Inspector's Report ACP-324021-26

Question	Whether the proposed extension and renovation of existing farm cottage (vacant) is or is not development and is or is not exempted development
Location	Killeenavarra, Kinvara, Co. Galway
Declaration	
Planning Authority	Galway County Council
Planning Authority Reg. Ref.	ED25/141
Applicant for Declaration	Rory Foy
Planning Authority Decision	Is not exempted development
Referral	
Referred by	Rory Foy
Owner/ Occupier	Rory Foy
Observer(s)	N/A
Date of Site Inspection	13 th June 2025
Inspector	Sarah O'Mahony

Whether renovation of an existing dwelling to include demolition of 37 square metres of domestic extensions to the rear of dwelling, demolition of water tank and shed (combined 10.48 square metres) to the side of dwelling, and construction of 40 square metres extension to the rear, comprises development which is exempt development?

WATER TANK & BOILER HOUSE TO BE DEMOLISHED

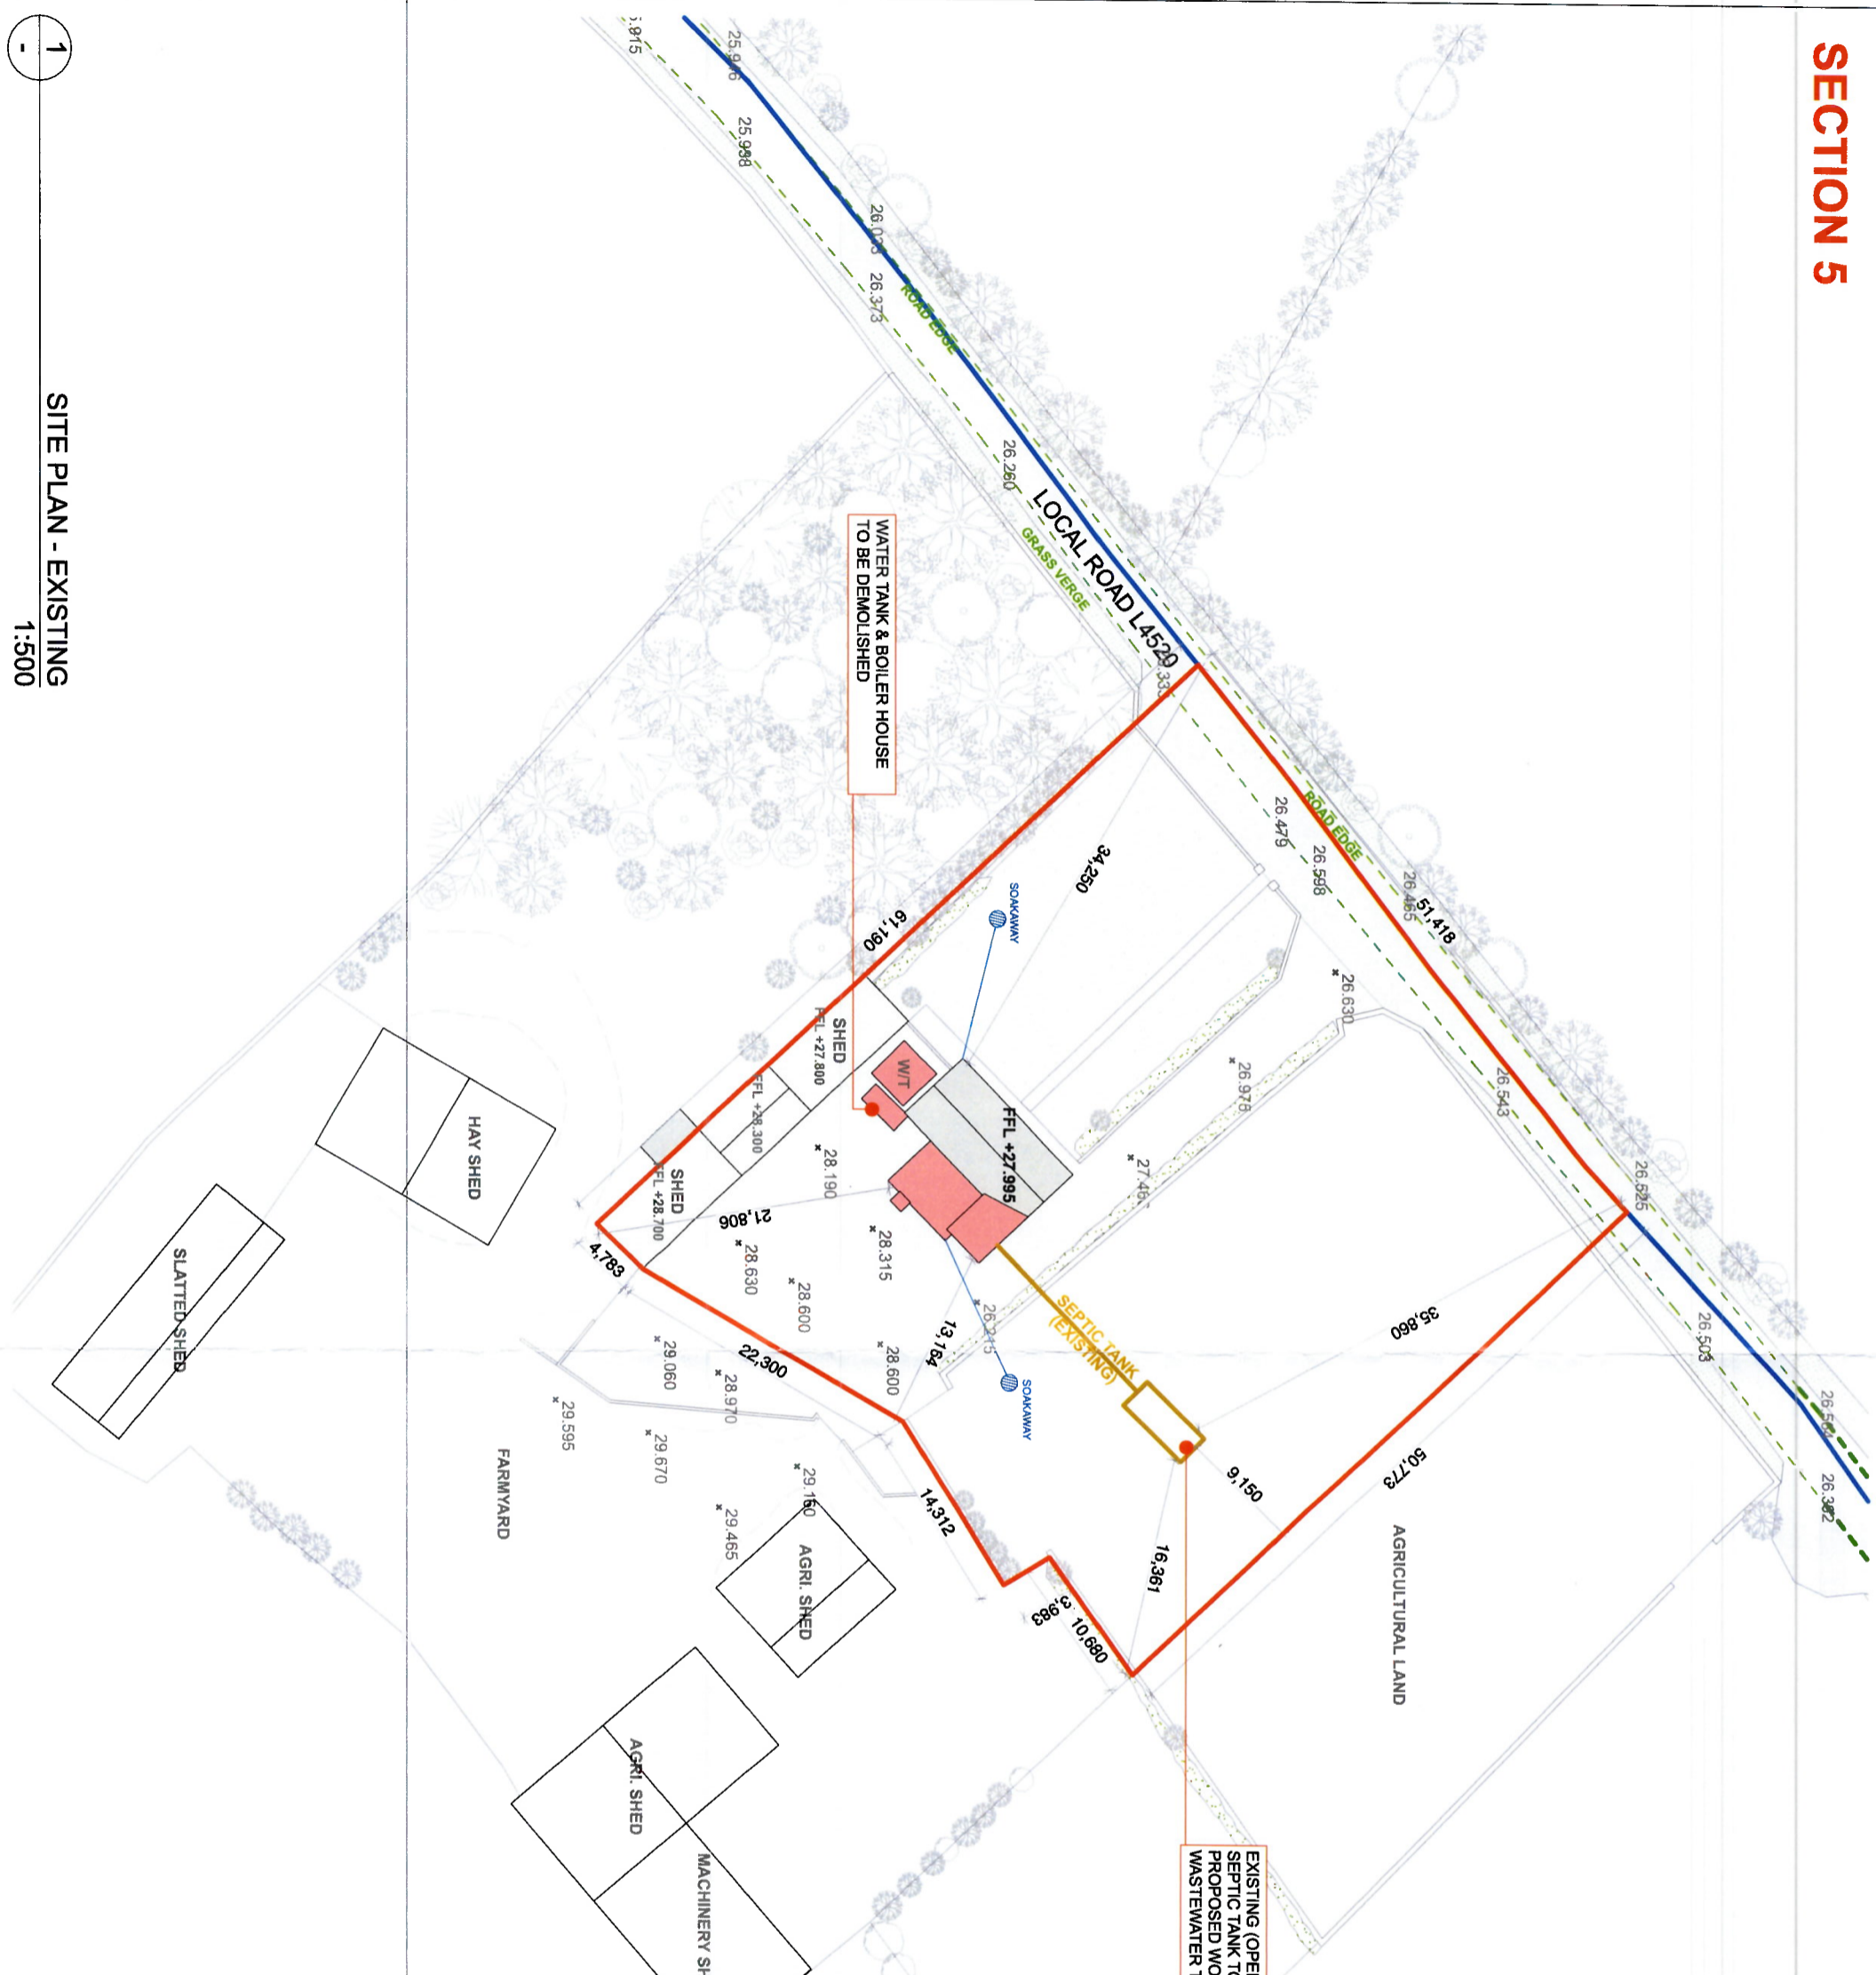
- 8.3.3. Demolition of the boiler room and water tank comprise demolition of buildings or parts of buildings within the curtilage of a house and within a farmyard which falls under the provisions of Class 50(a) and which meet the limits and conditions set out in column 2.
- 8.3.4. Demolition of the domestic extensions comprise demolition of part of a habitable house in connection with the provision of an extension in accordance with Class 1 which falls under the provisions of Class 50(b), but only in circumstances where the proposed extension is deemed to be in accordance with Class 1.

PROPOSED AREA (IN YELLOW) - 40m²

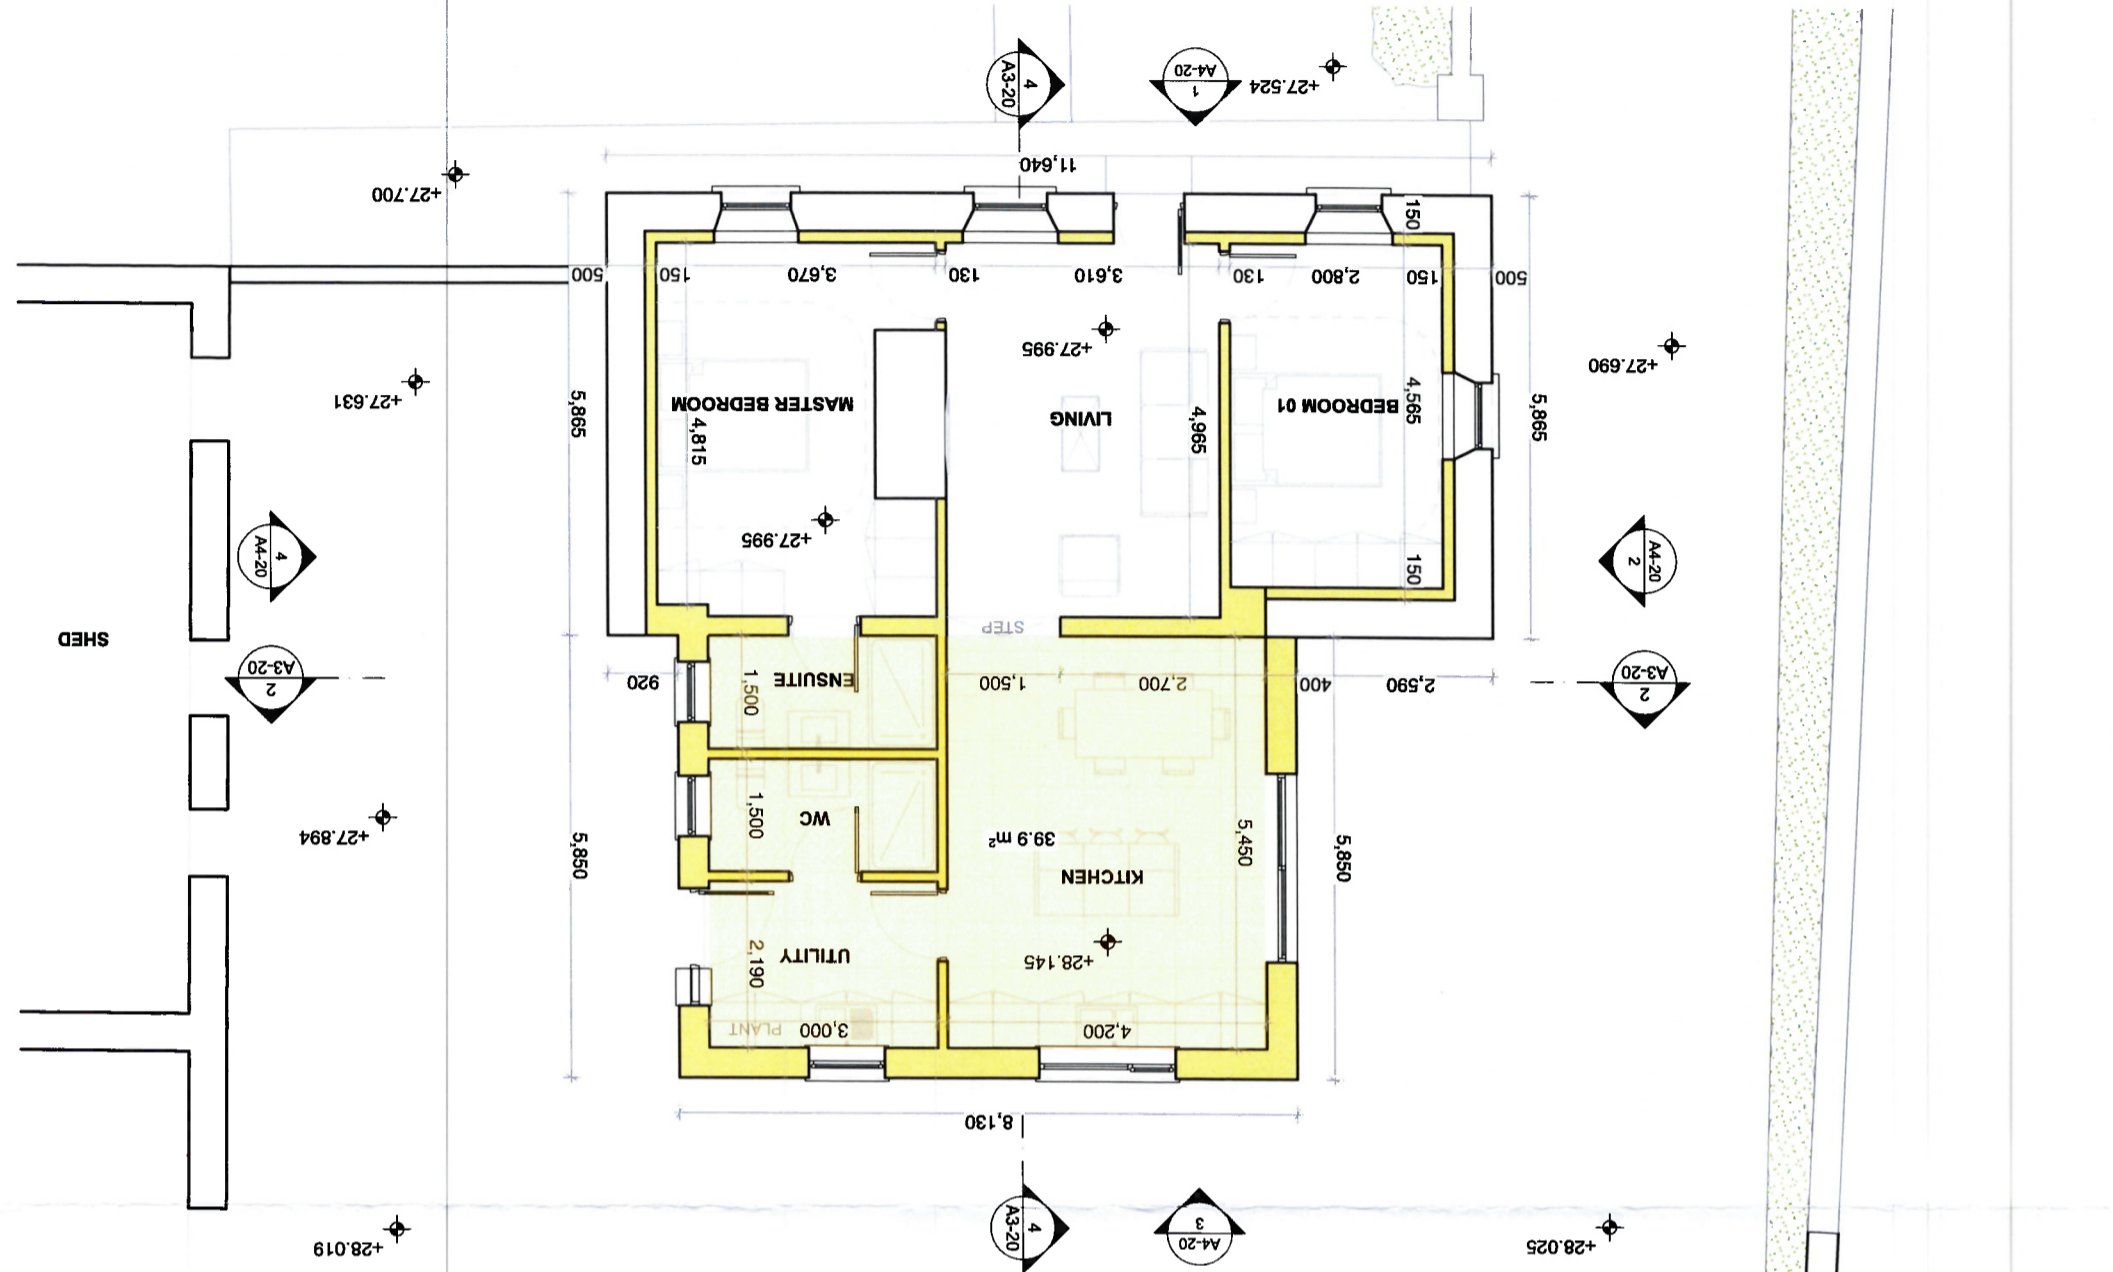
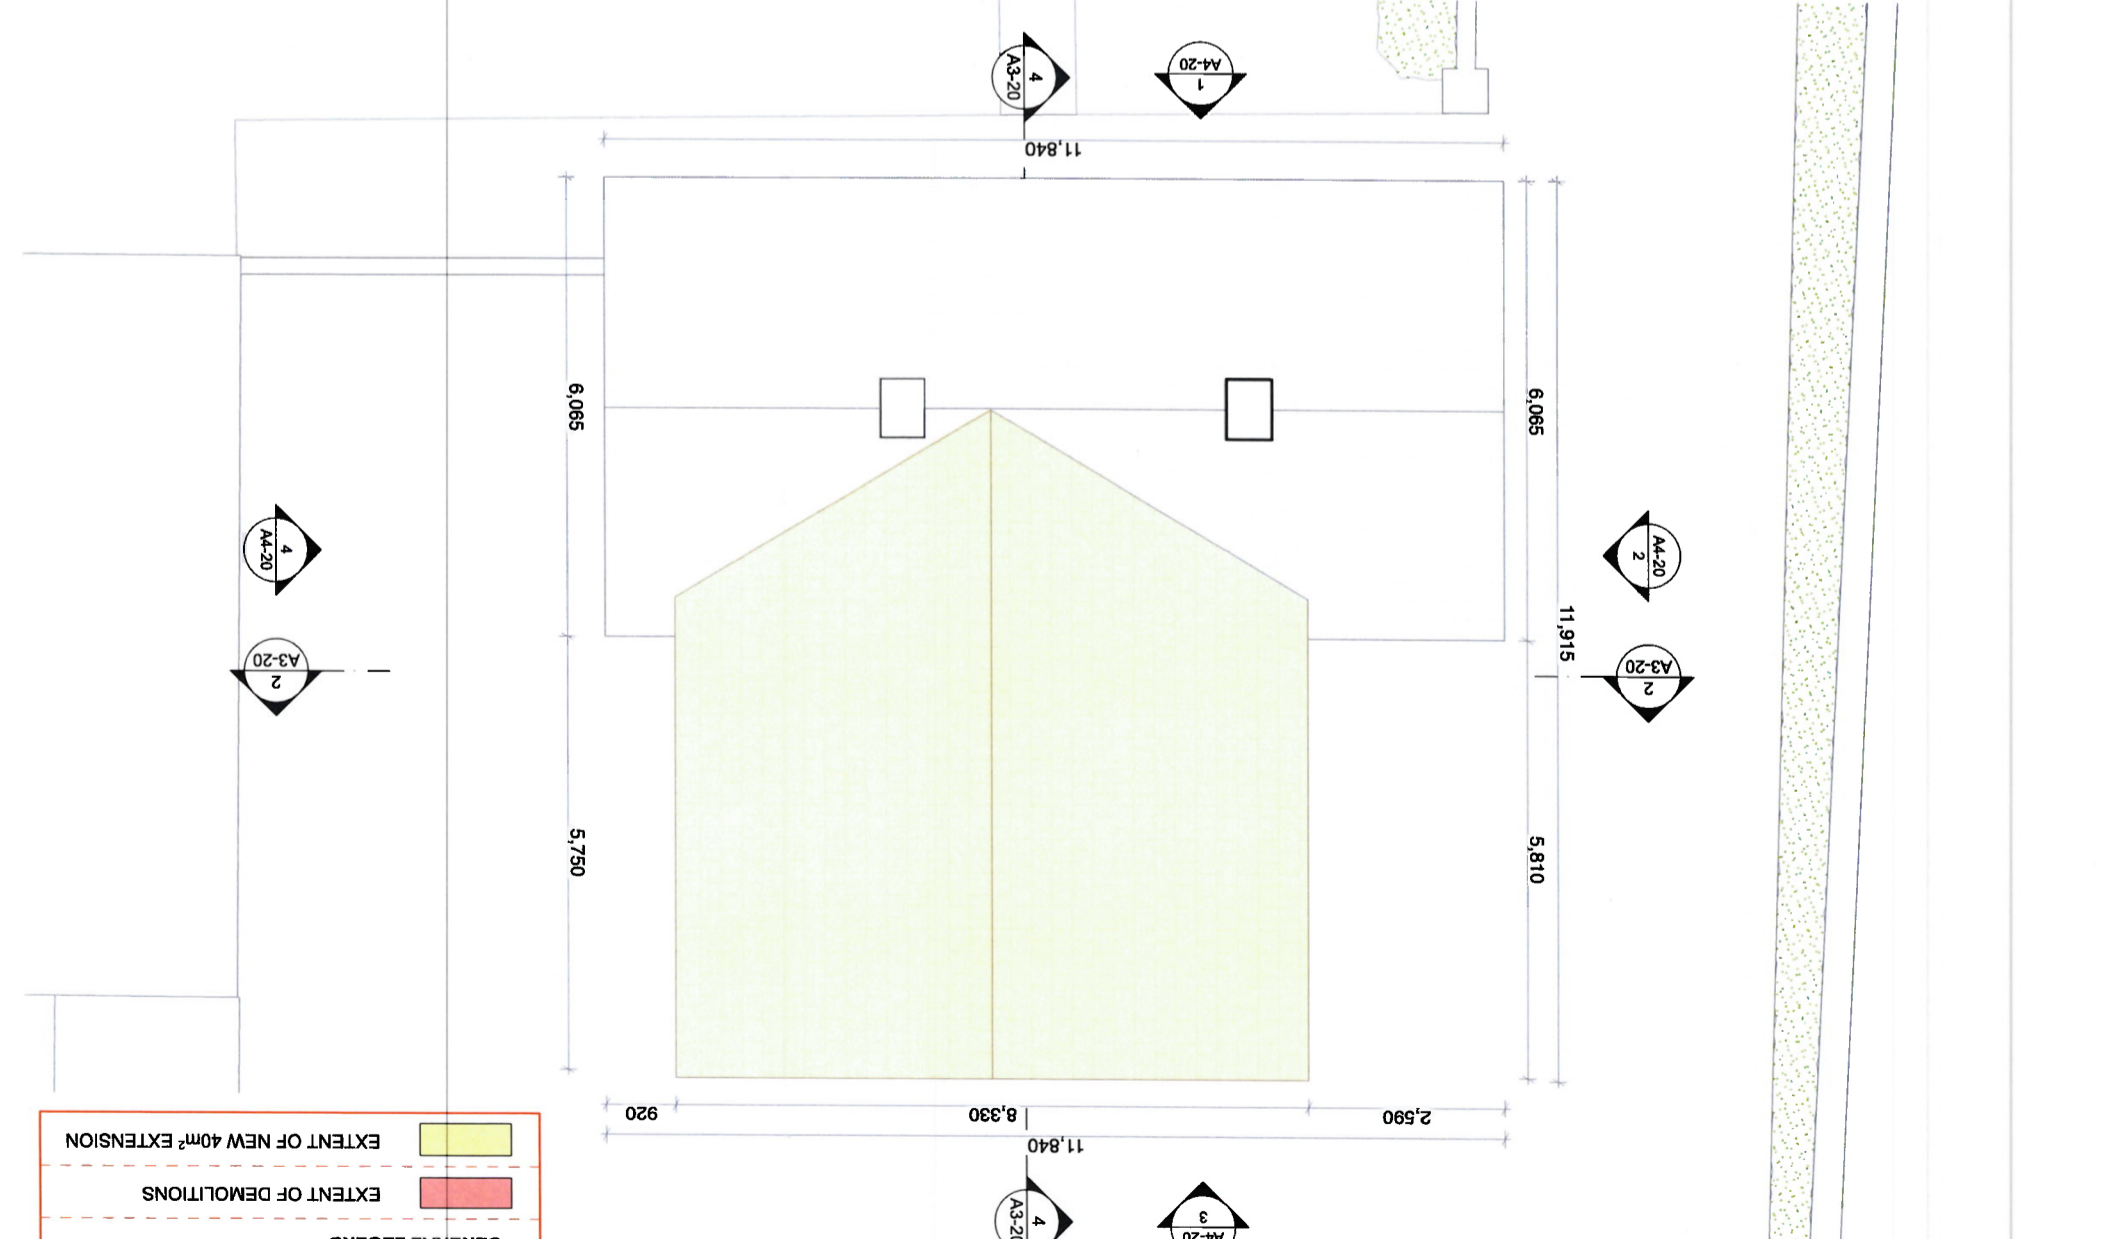
- 8.3.5. Class 1 of Schedule 2 of Part 1 of the Regulations provides that a domestic extension of 40m², situated to the rear of the main dwelling comprises exempted development subject to the additional conditions and limitations outlined above.
- 8.3.6. The proposed extension in this case, following demolition of the existing extension, would comprise 40m² which meets the limits in column 2. I note drawings submitted in this regard which illustrate how the proposed extension would extend slightly less from the rear elevation of the main dwelling than the previous layout proposed in ref. ABP-321734-25.
- 8.3.7. I note that the proposed extension would comply with the remainder of the limits and conditions prescribed in column 2 of class 1 and therefore consider the proposed development does comply with the provisions of Class 1 and therefore is exempted development.

8.3.8. Further, as the extension does comply with the provisions of Class 1 it therefore leads to the conclusion that the proposed demolition is also exempt development as it is connected with development which accords with Class 1. This conclusion disagrees with the Planning Authority's determination, however the rationale for reaching that determination is not set out in the report or determination.
